Construction Field Report

Lot/Subdivision: H SWEETWATER
1A HYBRID LN.

Notes: RE: BUILDING PERMIT REVIEW 1/24/2020

Group: AUTO
 Type: RESIDENTIAL-BUILDING
 Status: DISAPPROVED
 Date Submitted: 1/24/2020
 Date Completed: 2/2/2020
 Reviewer: Brad Sutton

INCREASE FOOTING SIZE AT
 LOCATIONS SHOWN FOR 4-PLY
 LAMINATED BEAM ABOVE

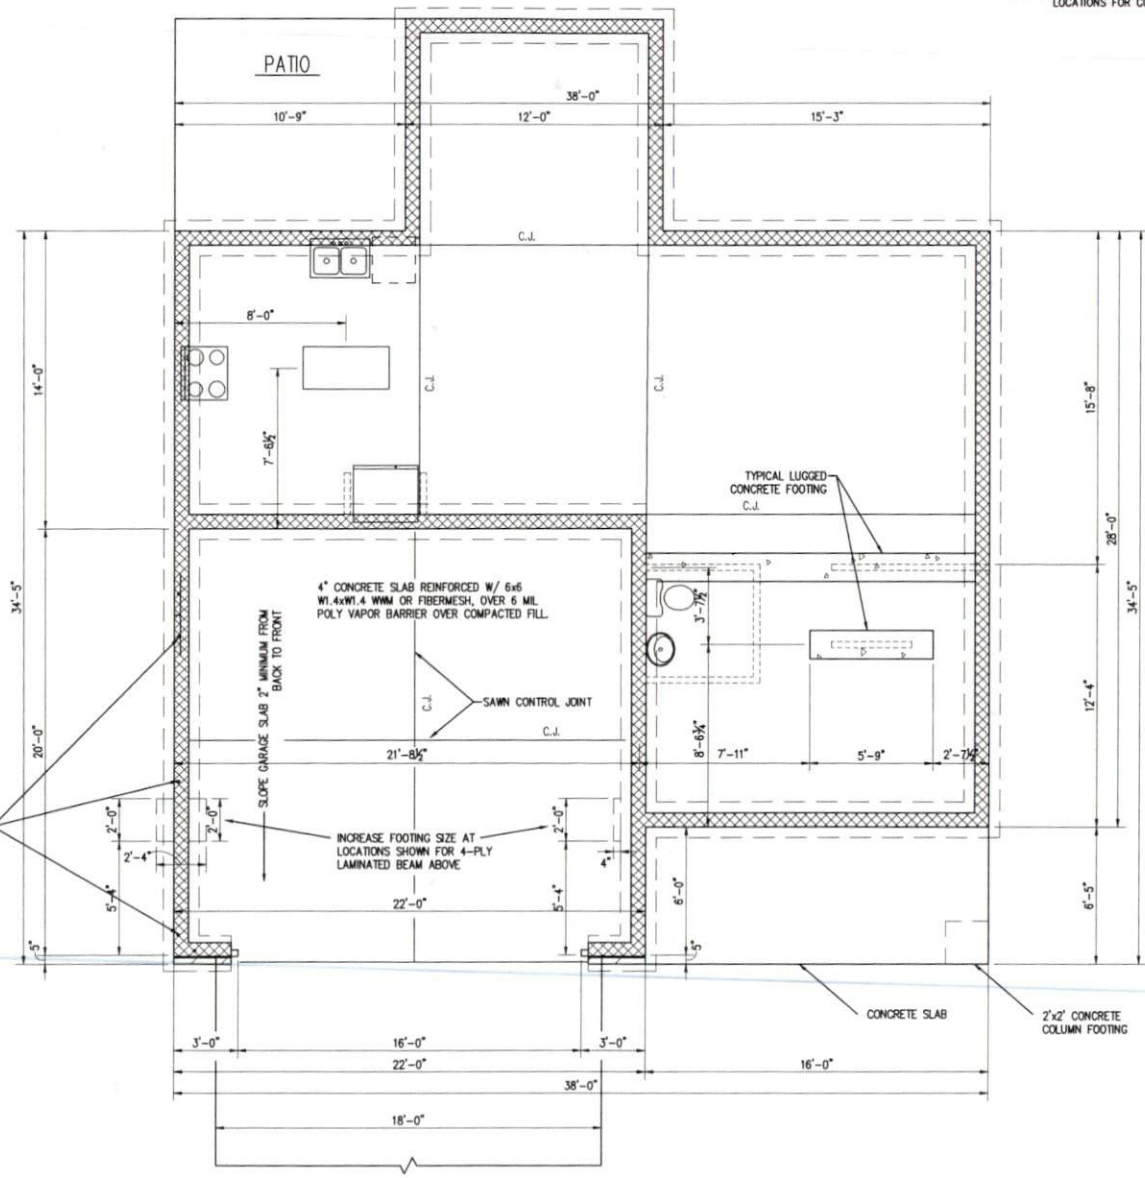
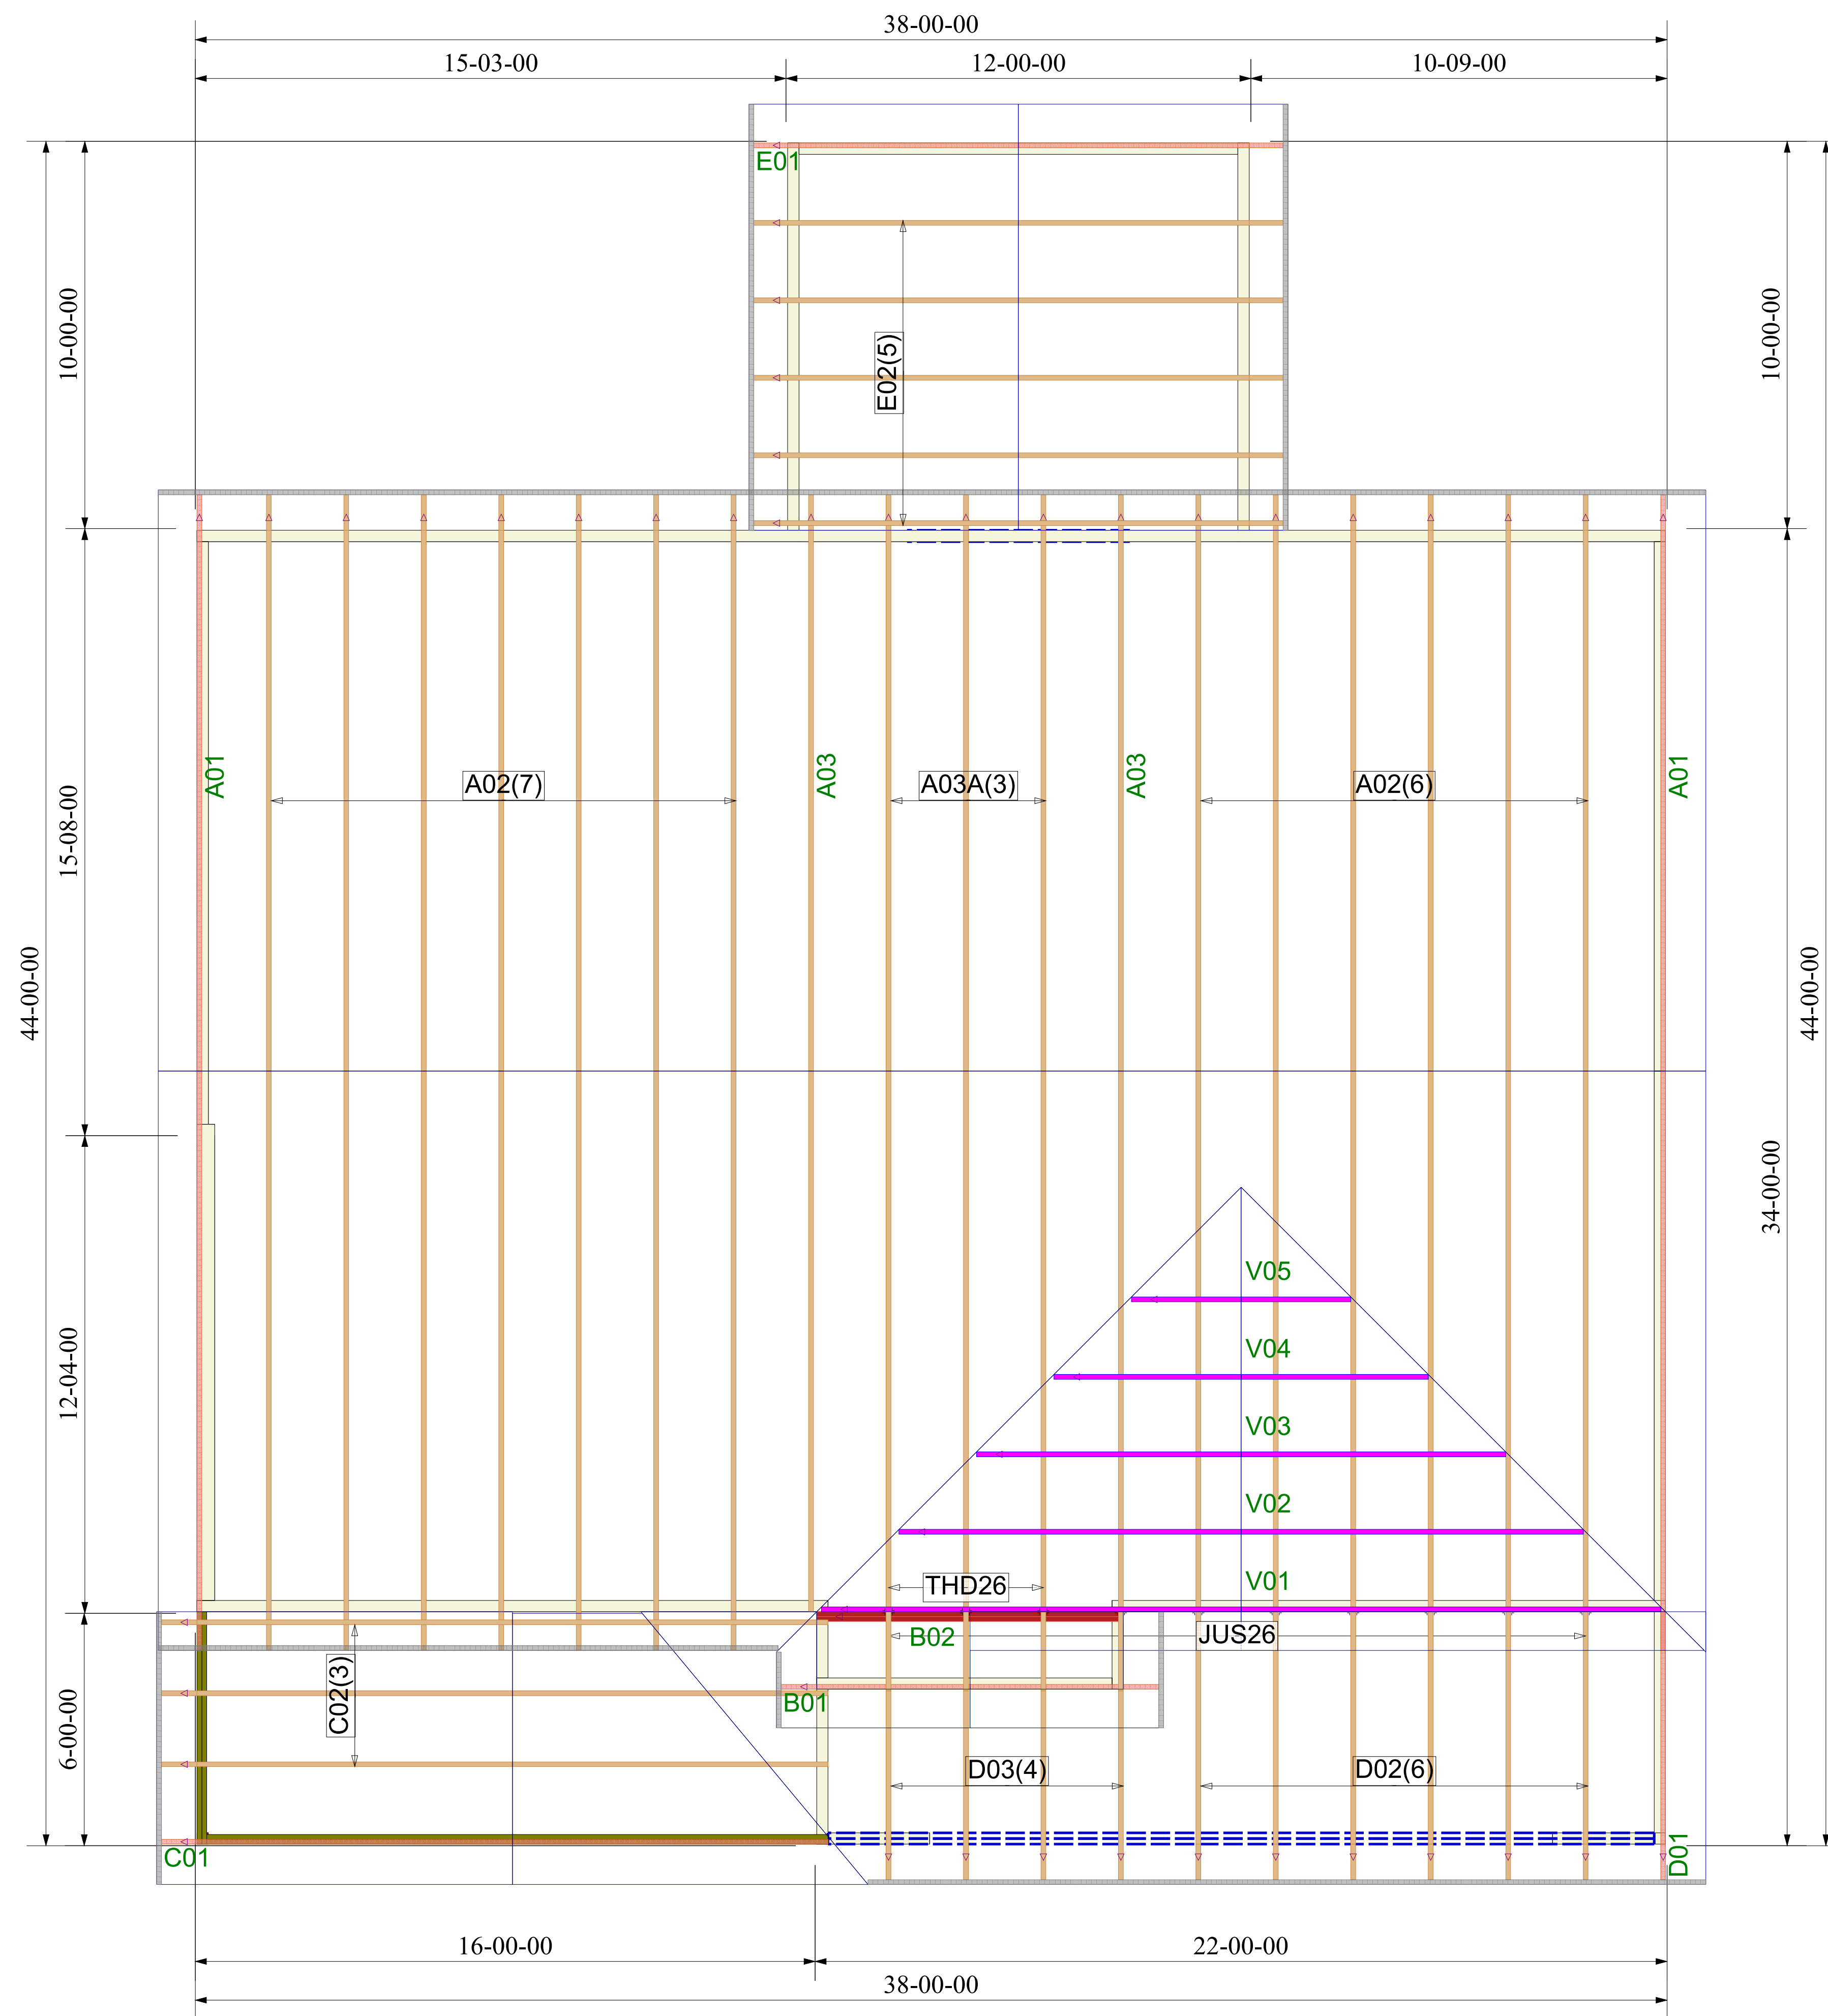
I CALCULATED THE BEAM END BEARING FOR THE
BI @ ITS HIGHEST LOAD OF 9,000 LB.
THE BEARING AREA IS APPROX 6.32 SF. AT A
POSSIBLE SOIL BEARING CAPACITY IT WOULD ALLOW FOR
A 17,600 LB LOAD.

Notes: 2/2/2020 2:59:14 PM
 Improper footing at Beam 1. Floor trusses F04 not loading on a beam or load bearing wall with a footing

SINCE THE BEAM LOAD IS PRETTY SIGNIFICANT,
I WILL GO AHEAD & BRACE UP THE FOOTINGS
AS WE DISCUSSED.

WE WILL UPLOAD A NEW FOUNDATION PLAN
WHEN WE SEND THIS PERM.
